**State Significant Development – SSD-5093
M2 site, North Ryde Station Urban Activation Precinct**

As such, Sydney Trains has undertaken a review of this development proposal and provides the following comments:

Site Plan

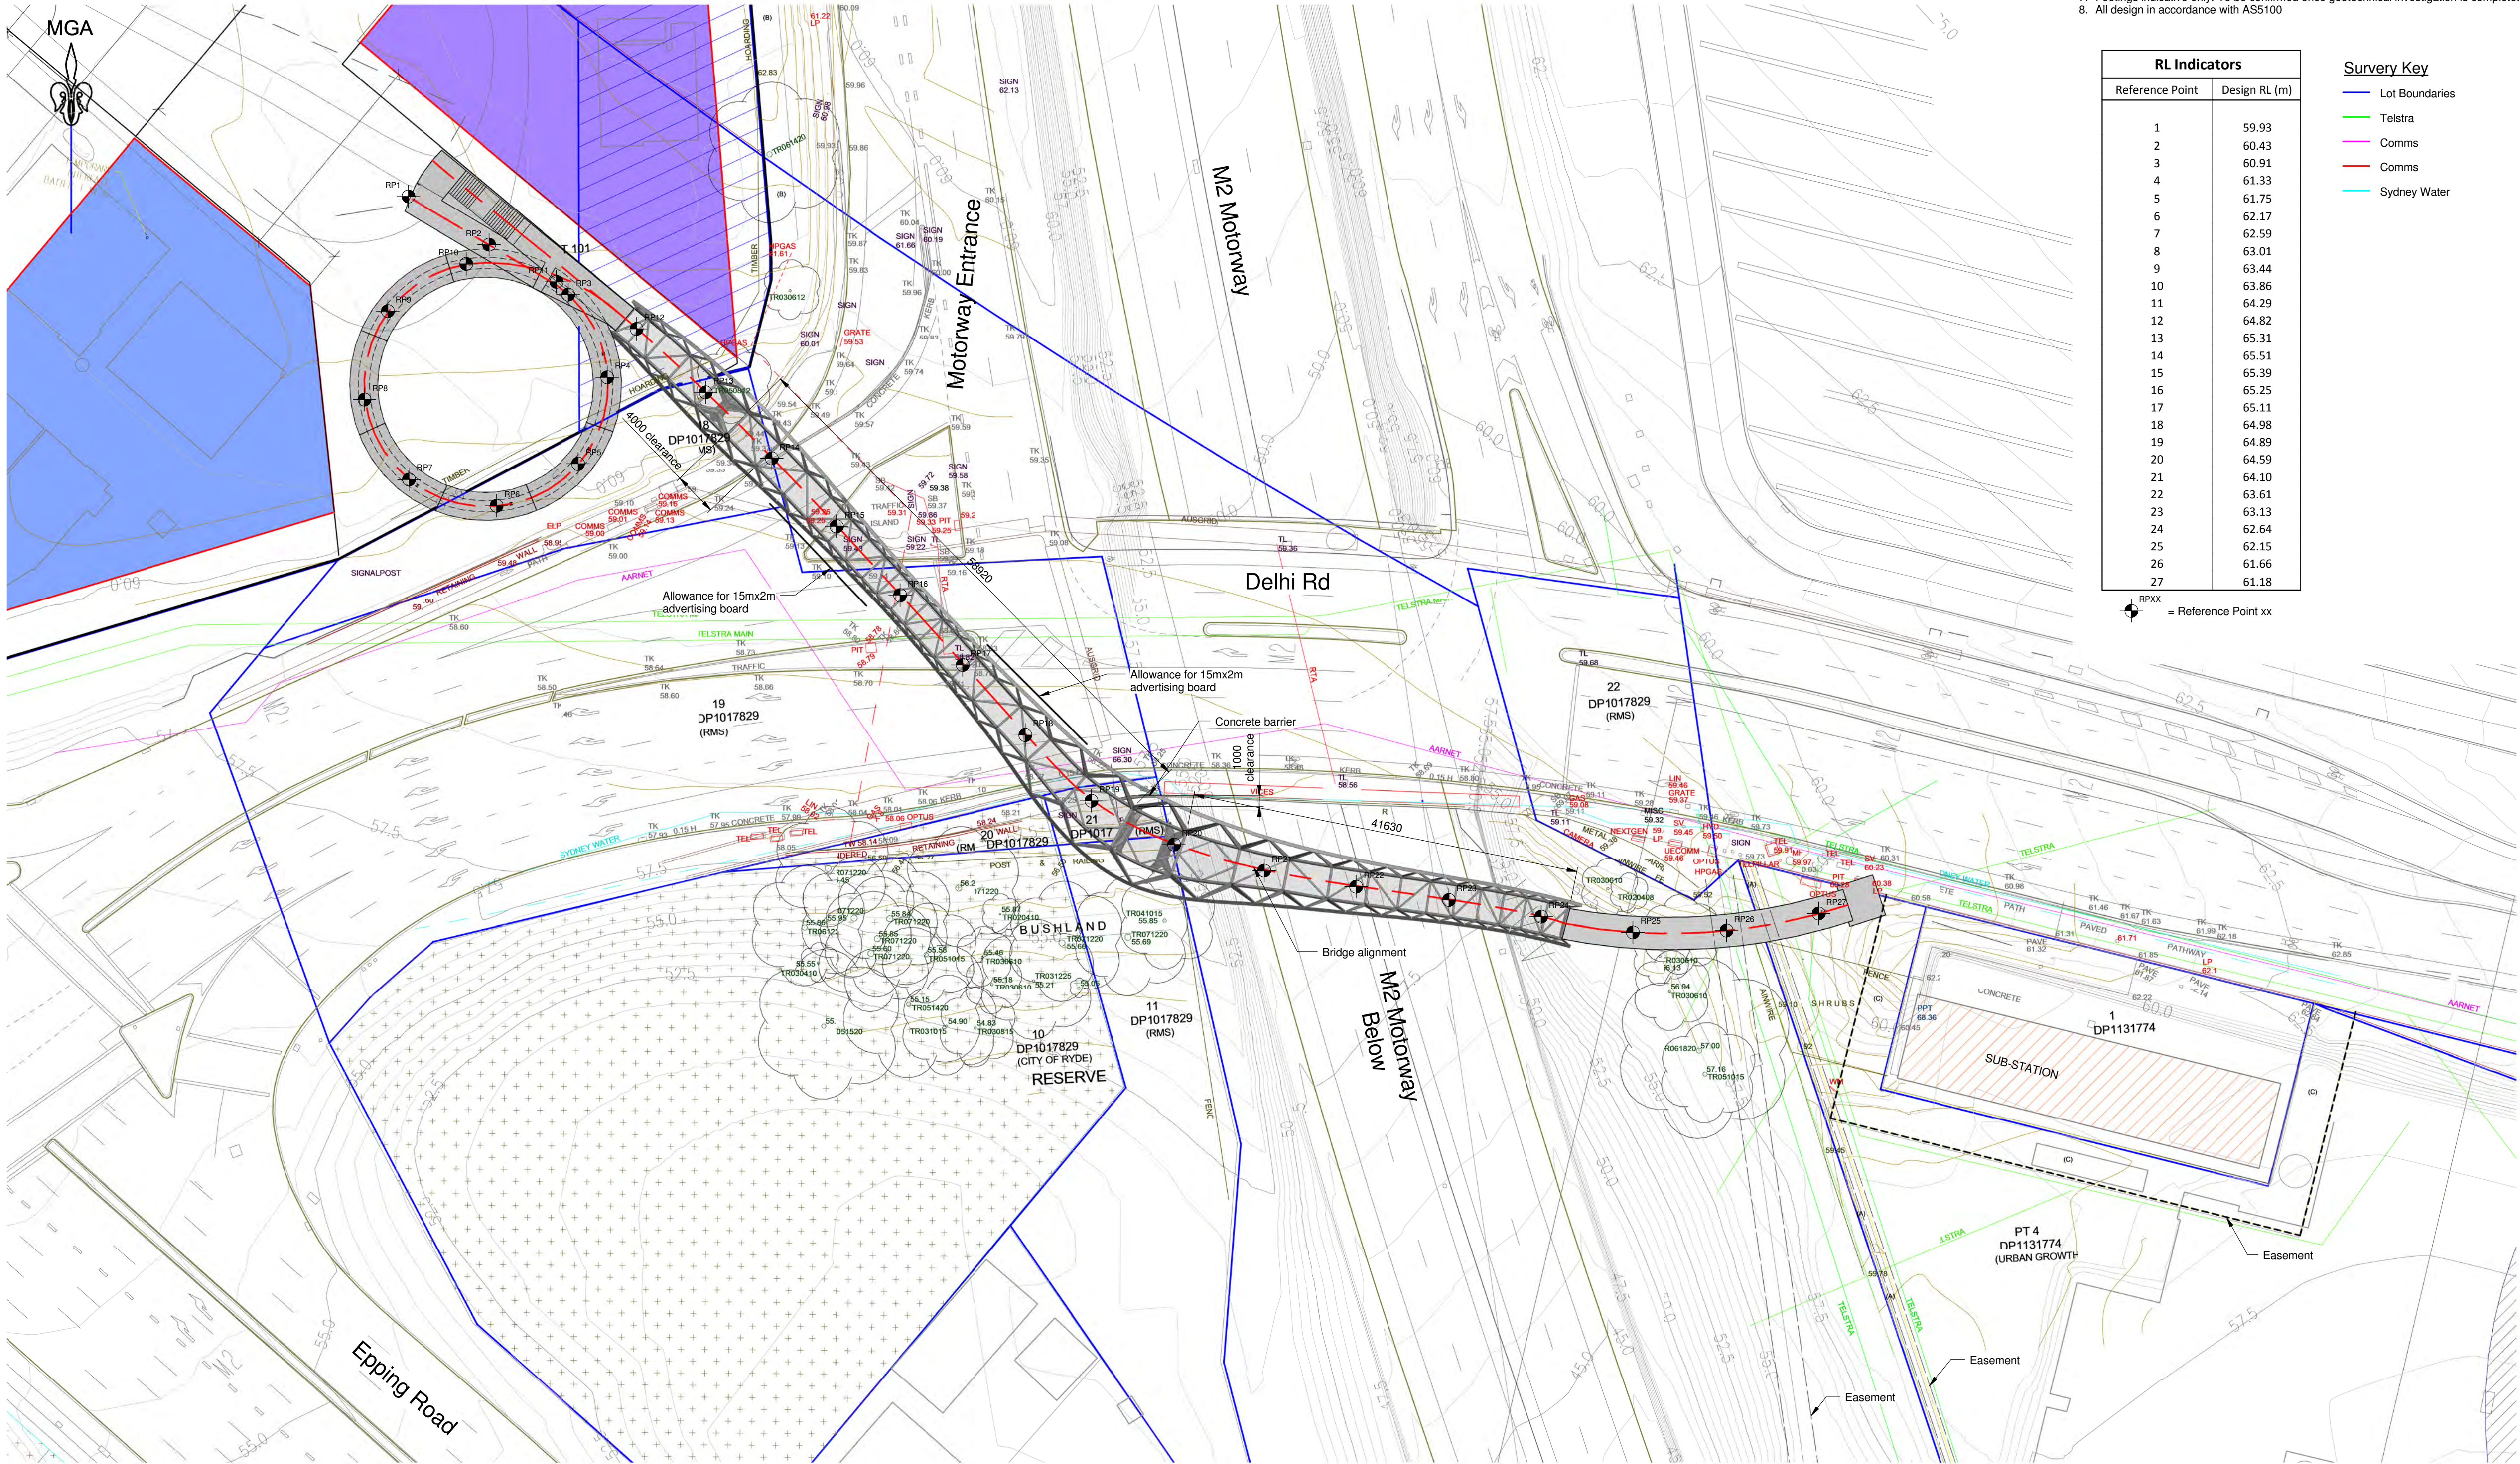
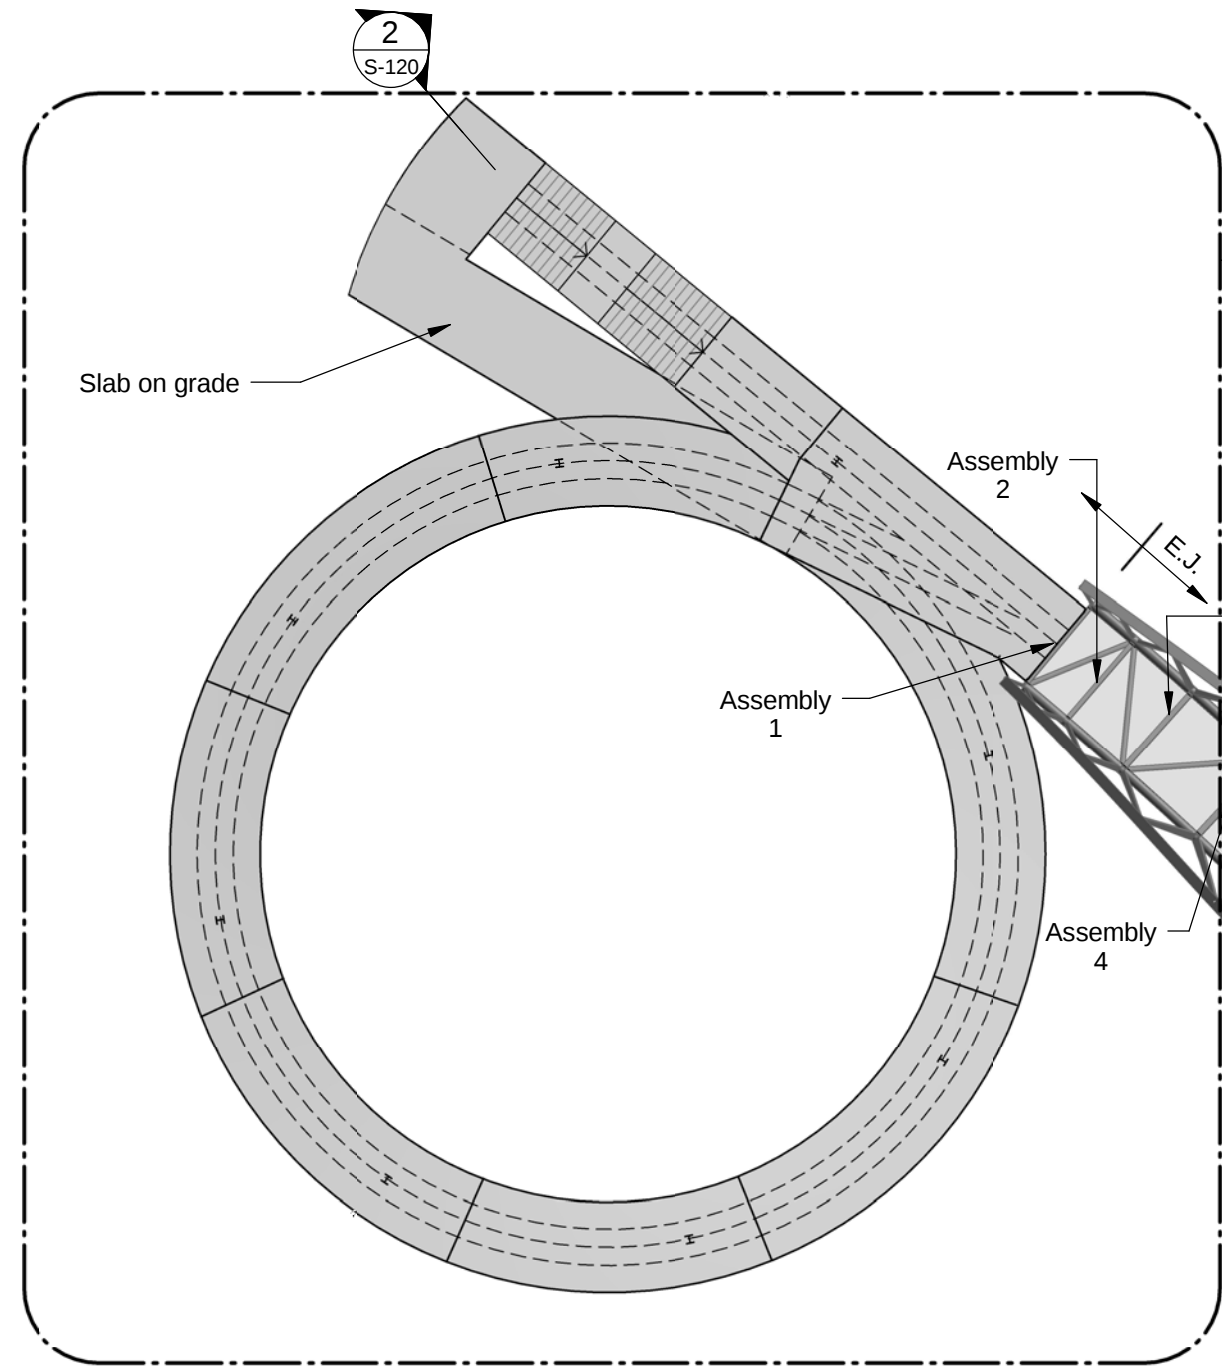
- *The shared pedestrian and cycle bridge is to be modified to ensure that no part of the bridge is located within the Sydney Trains easement surrounding the substation located on Lot 1 DP 1131774.*

- *No bridge columns/piers are to be installed above or within 25m of the rail corridor until the following documentation has been submitted to, and endorsed in writing by, Sydney Trains:*

1. *Final Geotechnical and Structural report/drawings that meet Sydney Trains requirements. The Geotechnical Report must be based on actual borehole testing conducting on the site closest to the drainage system.*

2. *Final Construction methodology with construction details pertaining to structural support during excavation.*
 3. *Final cross sectional drawings showing ground surface, drainage infrastructure, sub soil profile, proposed basement excavation and structural design of sub ground support adjacent to the drainage system. All measurements are to be verified by a Registered Surveyor.*

4. *Detailed Survey Plan showing the relationship of the proposed developed with respect to the Sydney Trains drainage system.*
 5. *If required by Sydney Trains, an FE analysis which assesses the different stages of loading-unloading of the site and its effect on the rock mass surrounding the rail corridor.*
